TO: All Staff
FROM: Public Works Planning Review Team
DATE: January 26, 2021
SUBJECT: BL-20-00032 Evergreen Valley

The Public Works Department has reviewed the Request for Boundary Line Adjustment Application. In order to ensure that it meets current Kittitas County Road Standards, the applicant needs to provide the following prior to final approval:

**EVERGREEN VALLEY PLAT DIVISION NO. III**

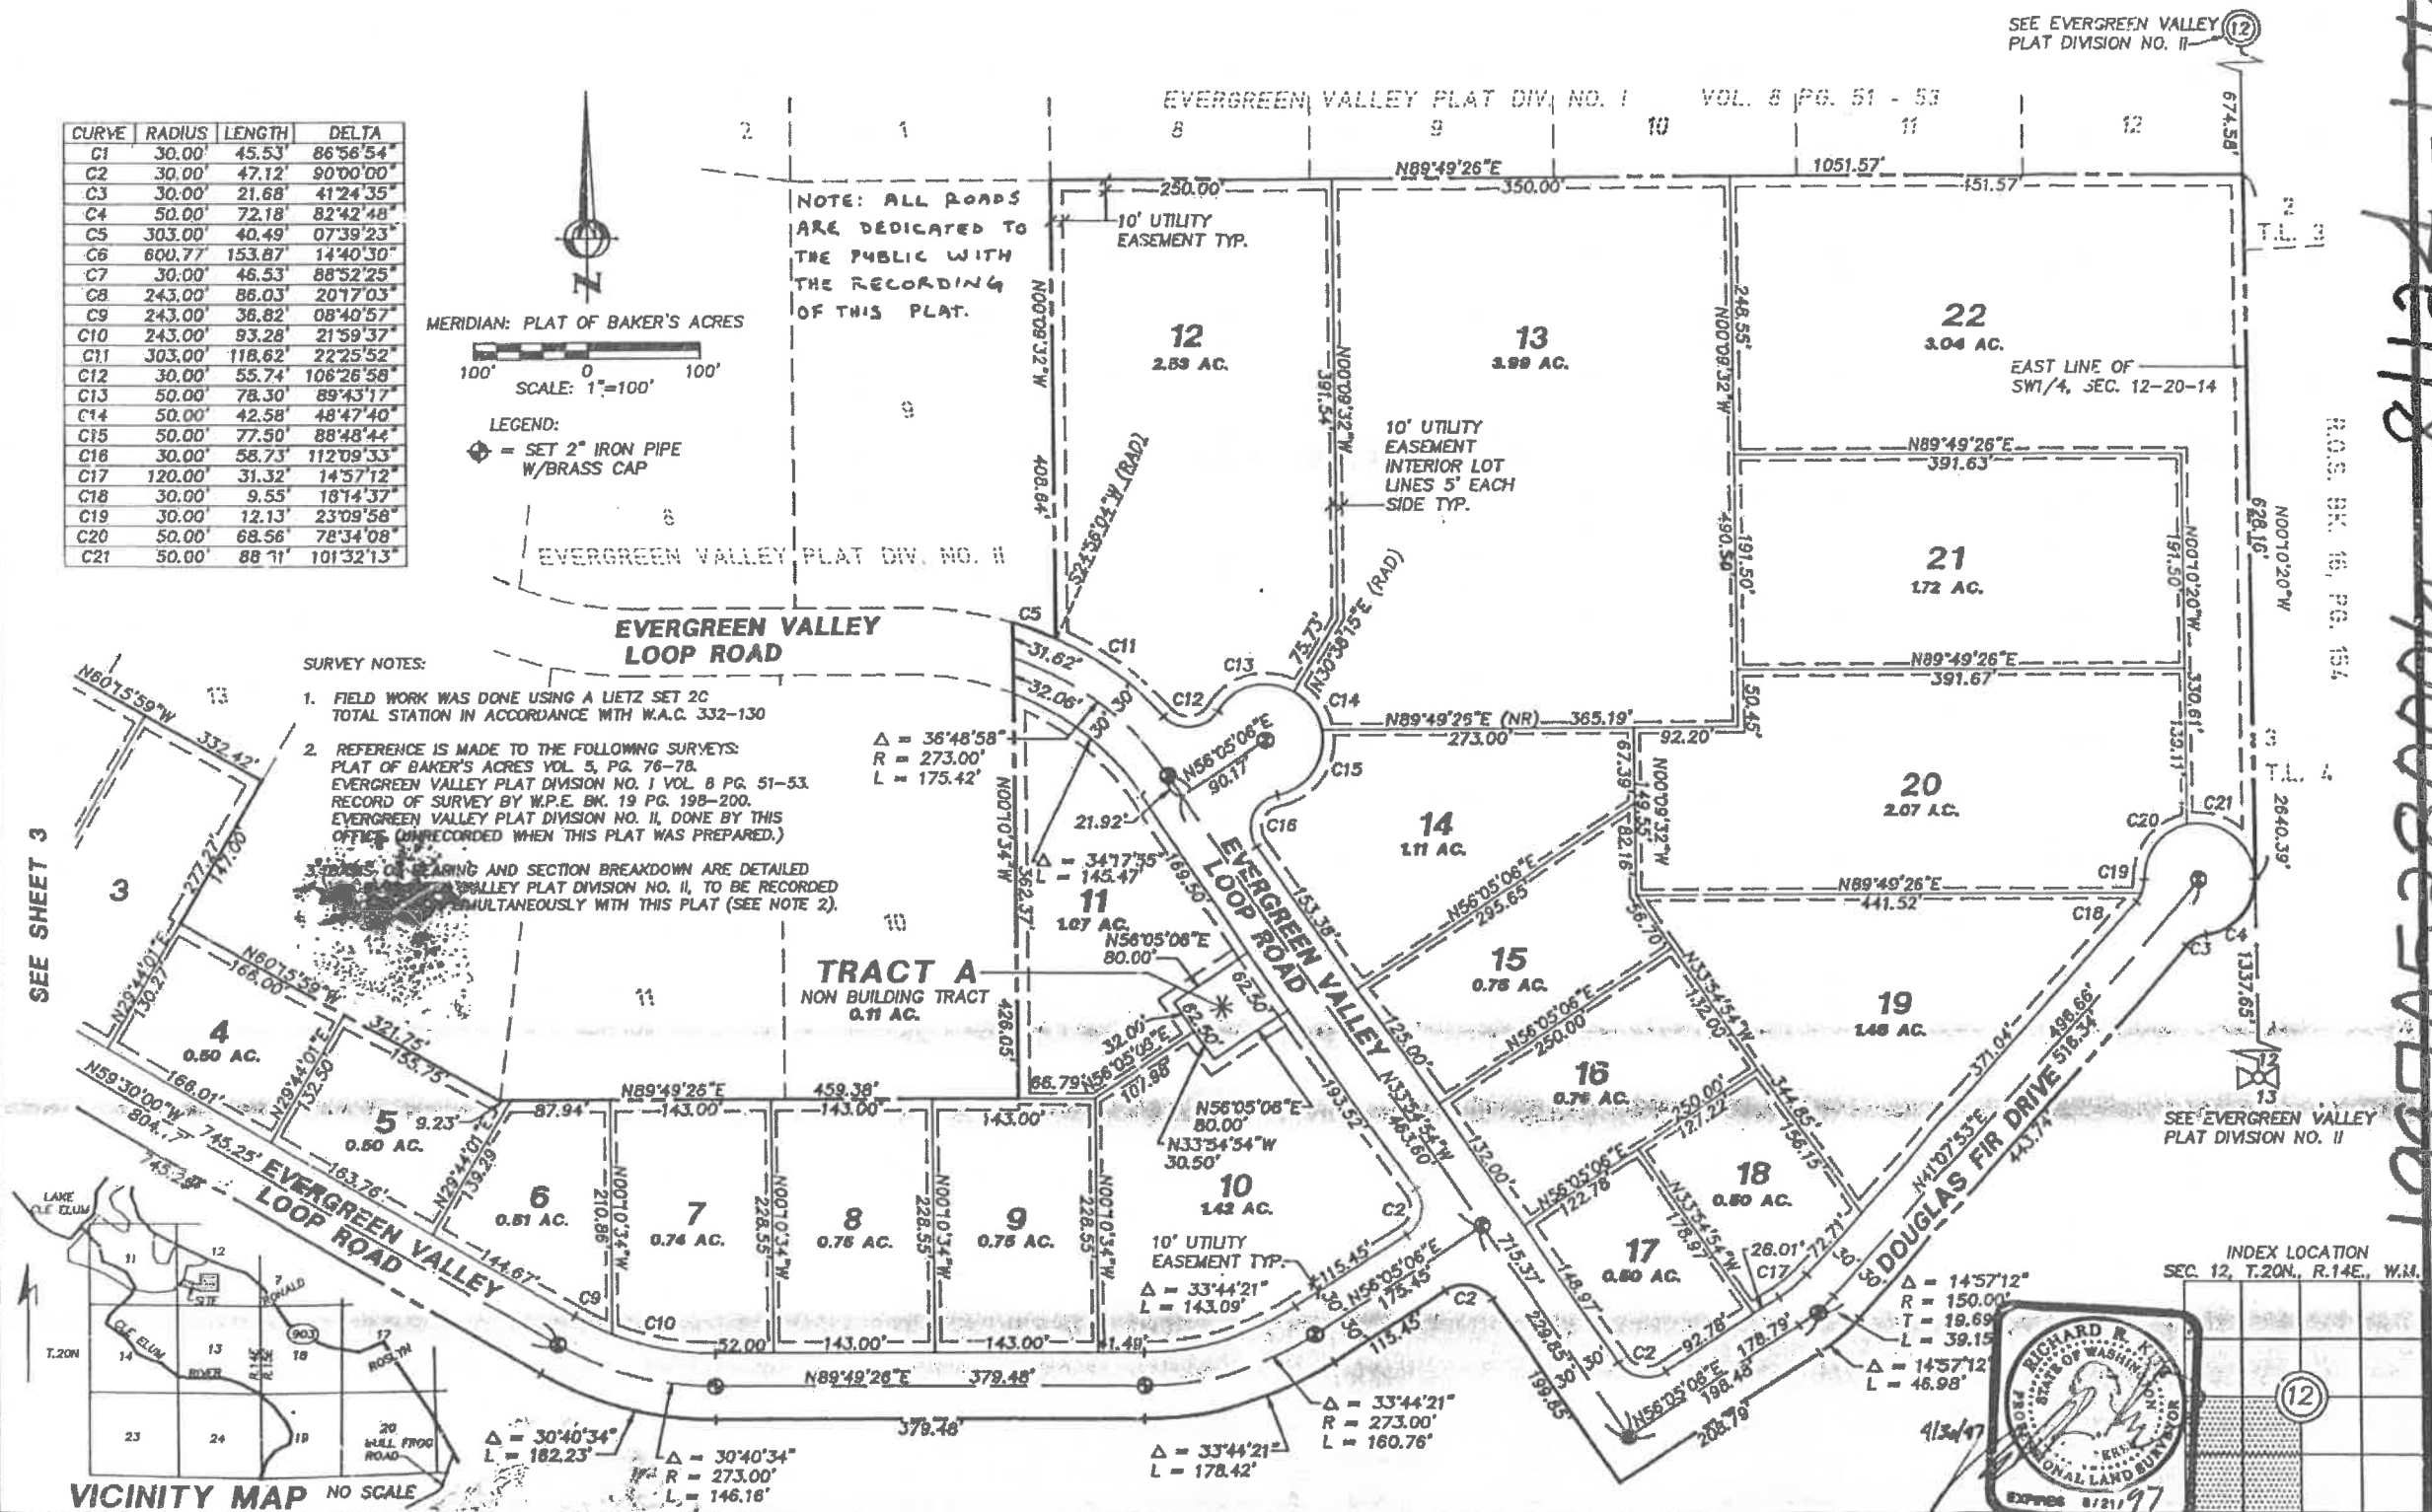
1. A revised legal description that describes the final configuration of the subject property shall be required.
2. A survey map for review. Any comments regarding the survey map will be reserved for final.
3. Proof of legal access to parcel 12171 (Lot 21). No access is shown to serve lot 21 on the plat map or new boundary line proposal.
